**From:** Nigel Locke [REDACTED]  
**Sent:** 03 April 2017 14:27  
**To:** Andrew Wood  
**Subject:** Planning Application: EP/41/17/PL : Land adjacent to 4 Beechlands Cottages

JOB TITLE			
New house at Beachlands Close, East Preston			
CLIENT			
Dearden Homes			
DRAWING TITLE			
Proposed Plans and Elevations			
DATE	SCALE	DRAWN BY	CHECKED BY
Sept 2016		GIM	
JOB NO.	DRAWING NO.	REVISION	
1671	2.02	A

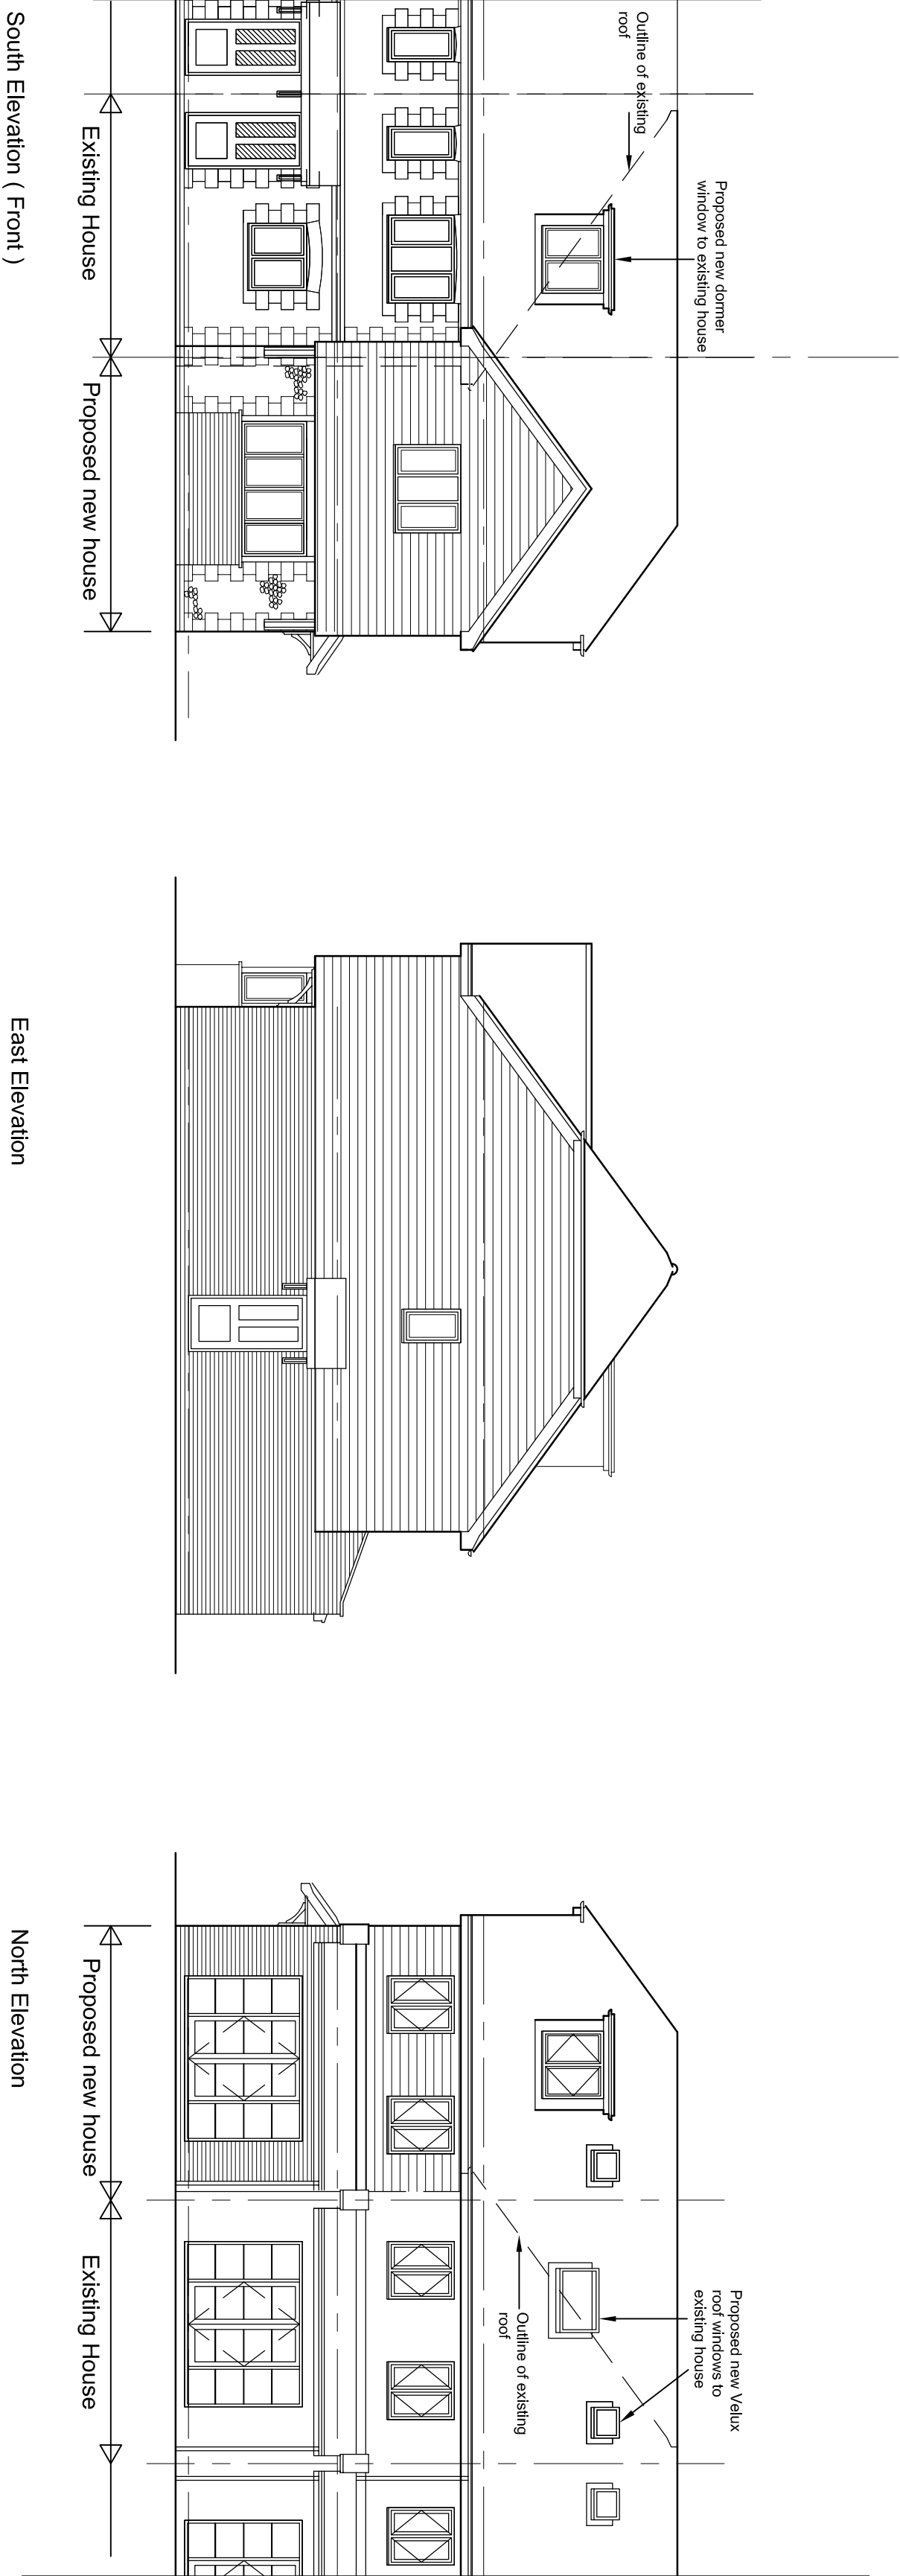
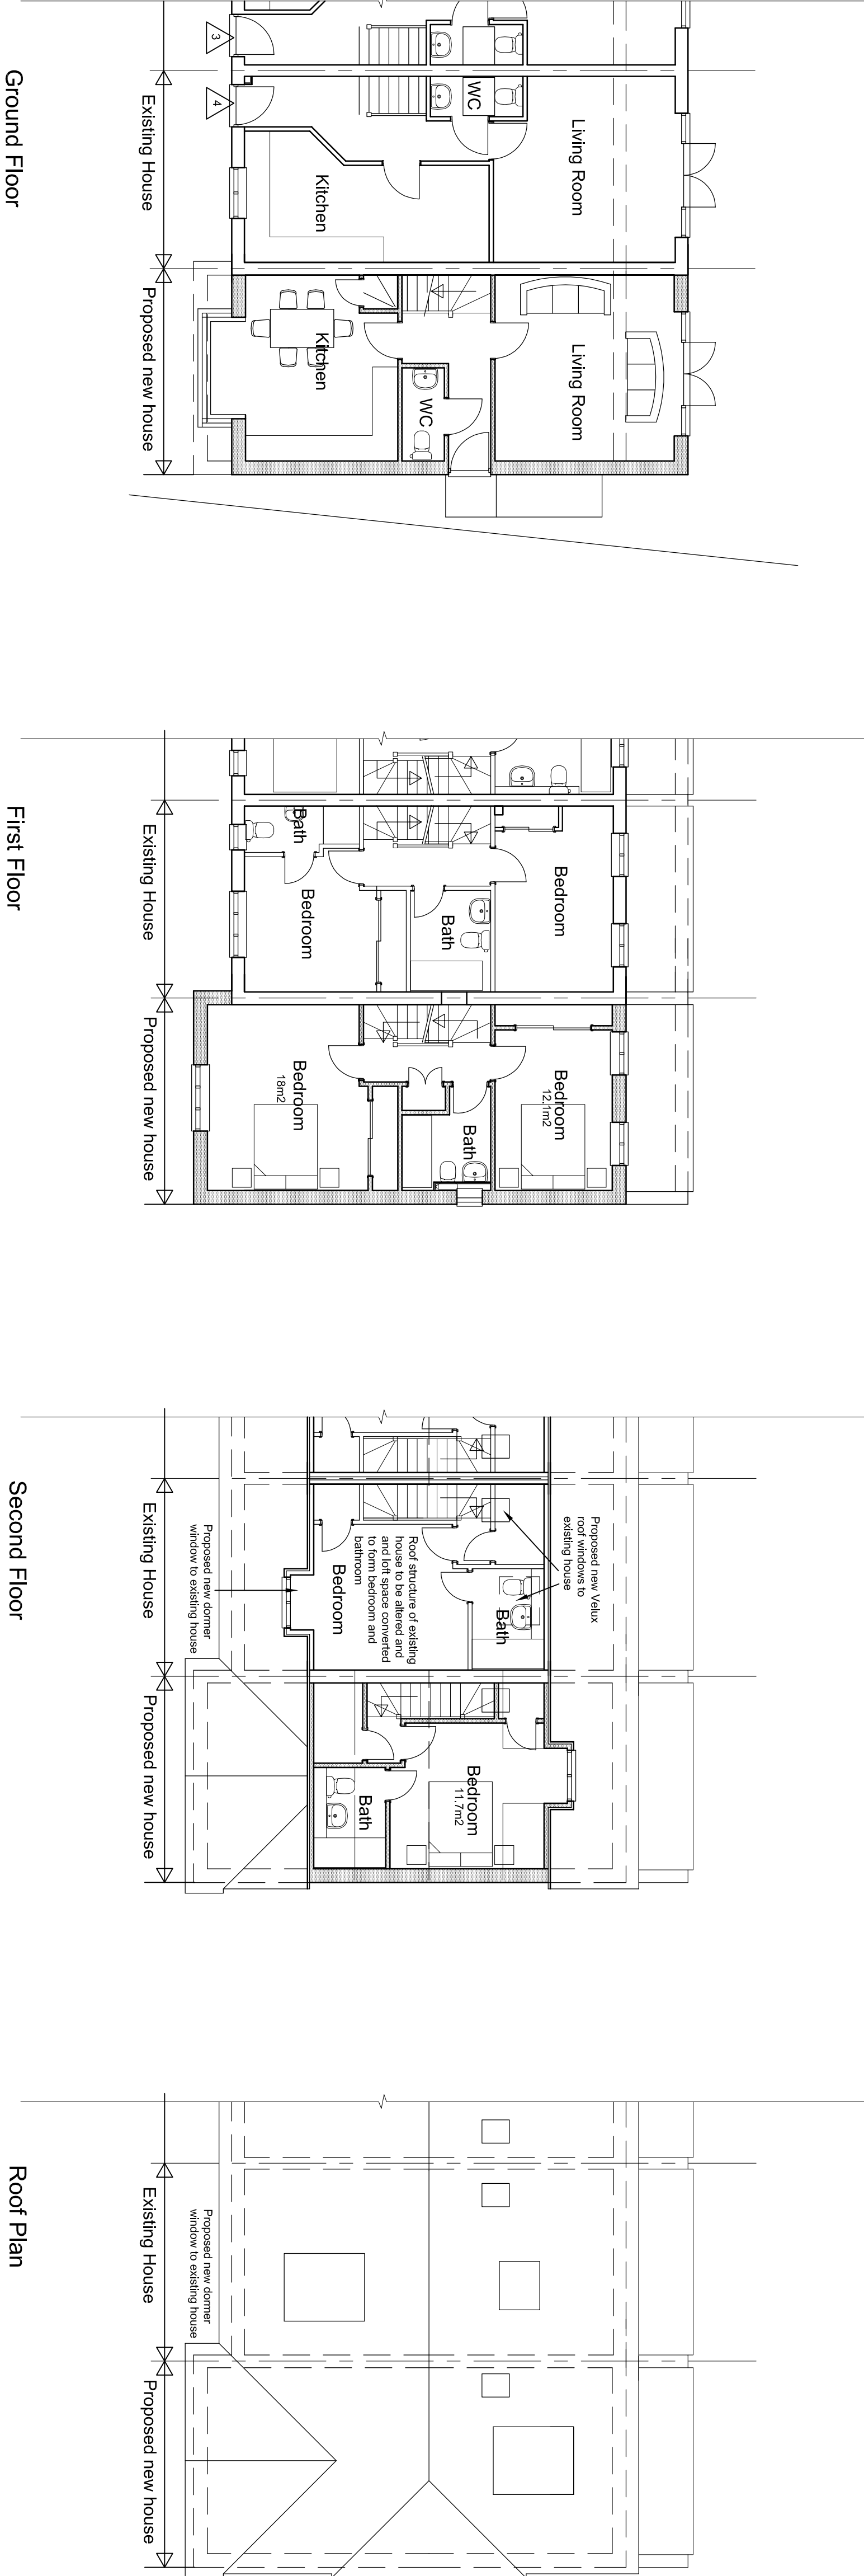
Further to your telephone message regarding the external materials this one, the applicant would be quite happy to change the external materials to be in keeping with the rest of the terrace.
